Our Ref: 09-374 GC:BL
Your Ref: DA09/0701.03 LN 35979

26 July 2018

Altitude Aspire Estate
MP09/0166 MOD 3
(Council Ref DA09/0701.3)
RFI Response to letter 11 May 2018

**Planning,
Industry &
Environment**

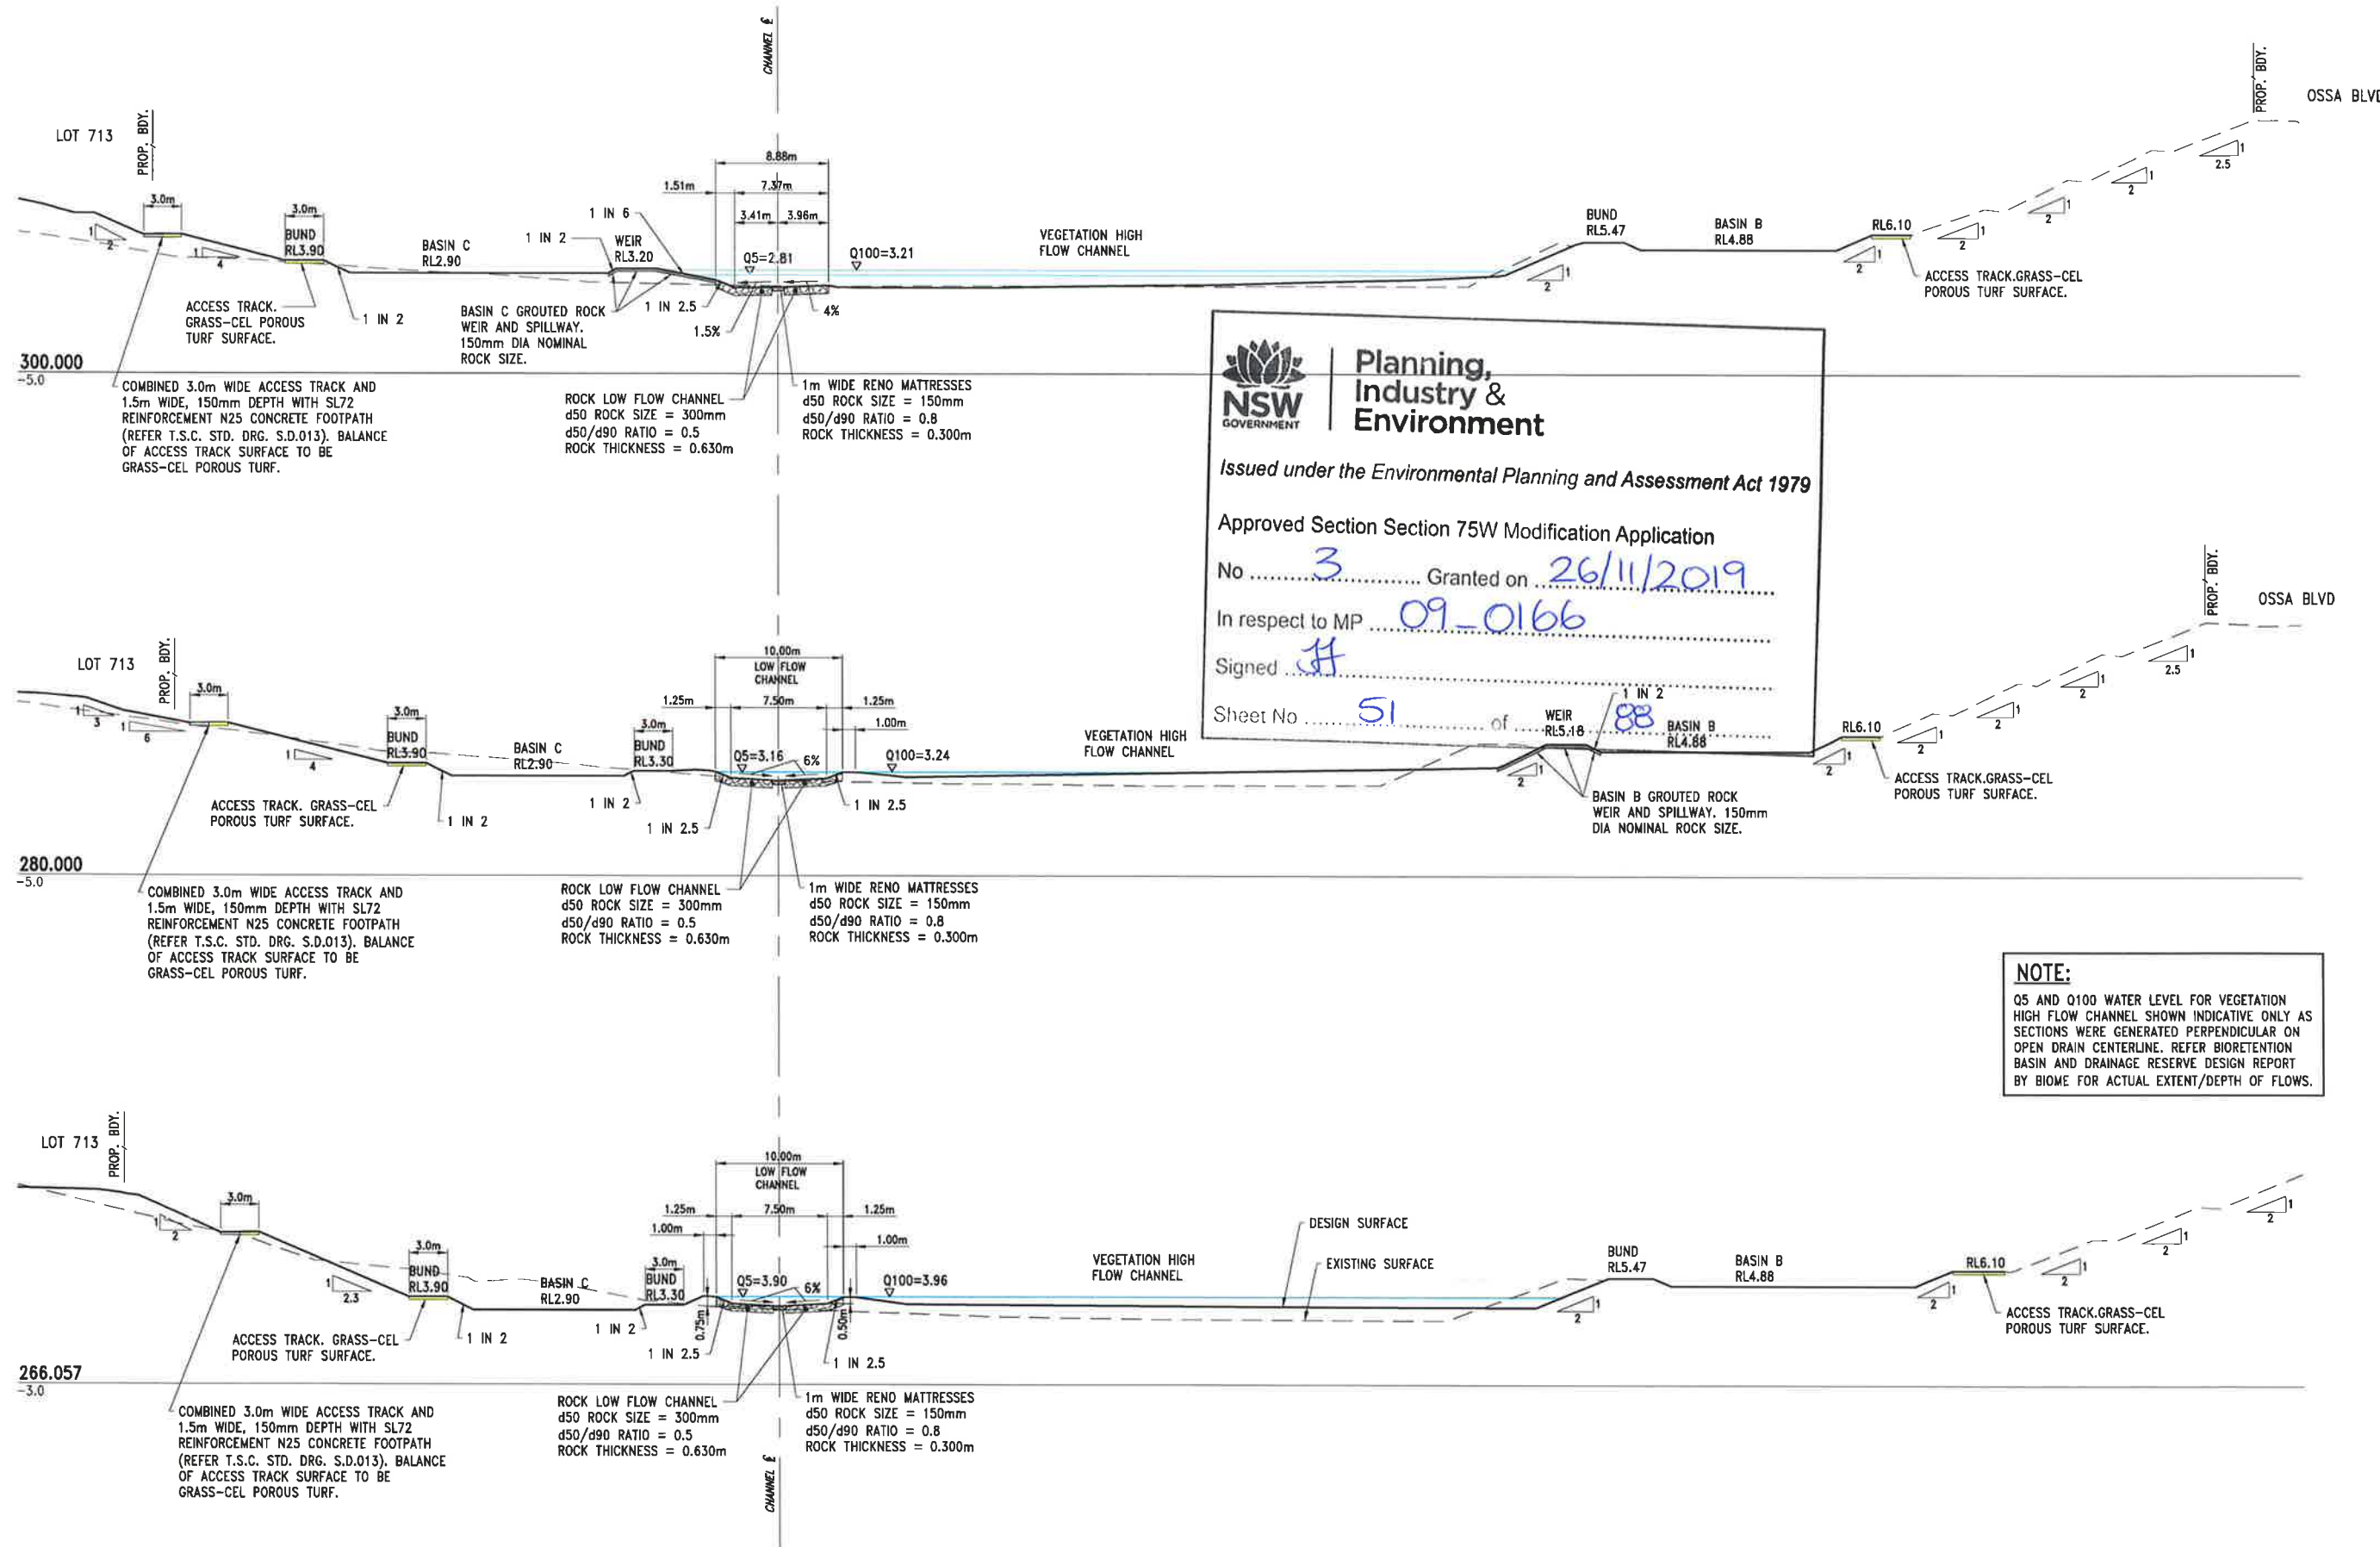
- c) Batter slope variability has been amended to reflect more closely Council concerns – refer long section drawing SK3619 Rev D and cross section drawings SK3620 Rev E to SK3625 Rev E inclusive.

- a) All batters within the Central Drainage Corridor have been revised so that no batter is steeper than 1 on 2. To protect against scour, all batters have been protected with rock rip-rap to the height of the expected 100-year ARI plus 300mm freeboard. Please refer to BIOME report also attached.

- d) Treatment of all batter slopes steeper than 1 on 4 have been detailed in FORM landscape drawings. To protect against scour, all batters at 1 on 2 within the drainage conveyance channel are to be treated, with rock rip-rap up to a height of the expected 100-year ARI plus 300mm freeboard.
